Our Ref: BRD-L-DPE-0008

Thursday 29 August 2019

Comment on Qantas Flight Training Centre Submissions Report (SSD 10154)

Figure 6 Overland flooding under existing conditions for 1% AEP event

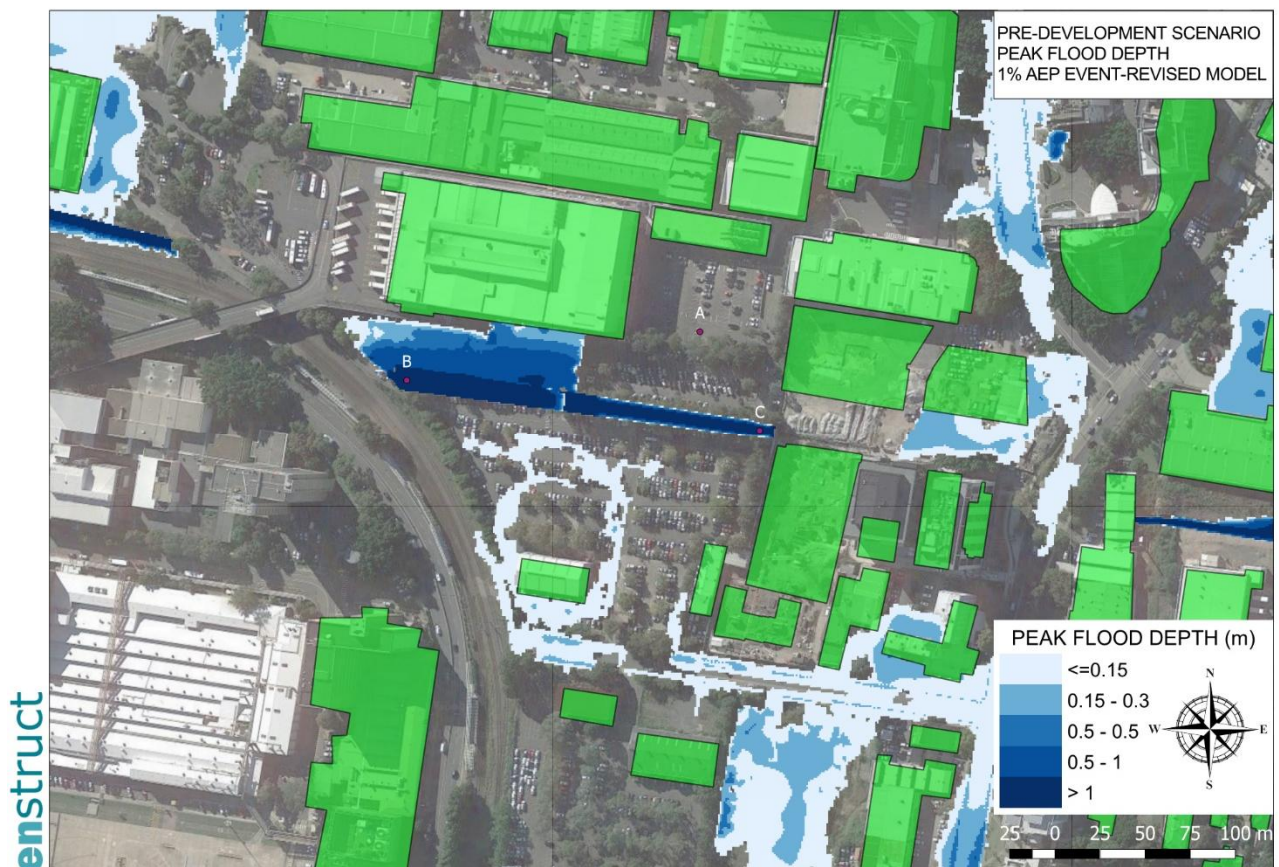
Item	Document Reference	ARTC EIS Comment	Qantas Response	ARTC Final Comment
			Refer to the revised Preliminary Construction Management Plan provided at Appendix L .	
9	Appendix Y - Stormwater Management and Civil Design Report Section 5 - Civil Engineering	<p>Fig 6 shows existing condition (pre-development) modelling only. The proponent should provide the post-development TUFLOW maps shown for 1% AEP to allow ARTC & Council to assess the impacts on the Botany Line for DPE to adequately understand the potential impacts onto ARTC rail corridor.</p> <p>ARTC does not support any impact as a result of increased stormwater overflow onto its rail corridor as it could significantly impact operations to and from Port Botany.</p>	As discussed earlier the proposed development will have no impact on flood levels or behaviour outside the site or on the ARTC corridor. Refer to further discussion and results of the flood modelling within the Amended Flooding Documentation, provided at Appendix O .	ARTC have no further comment regarding this item.

10	Stormwater Drainage Design Appendix A	The stormwater design within the development appears not to contain any on-site stormwater detention / attenuation devices to manage peak flows in to receiving systems. ARTC raise concerns with the increase in 1%AEP and PMF levels at Point B, Section 5 (Fig 6) & Table 3 of the same section.	The provision of an OSD system on the site is not necessary as stormwater discharges directly to the Sydney Water channel via the existing stormwater connections, with no impact on any Council stormwater infrastructure. This position has been confirmed within correspondence received from Sydney Water, provided within the Amended Flooding Documentation provided at Appendix O .	ARTC have no further comment regarding this item.
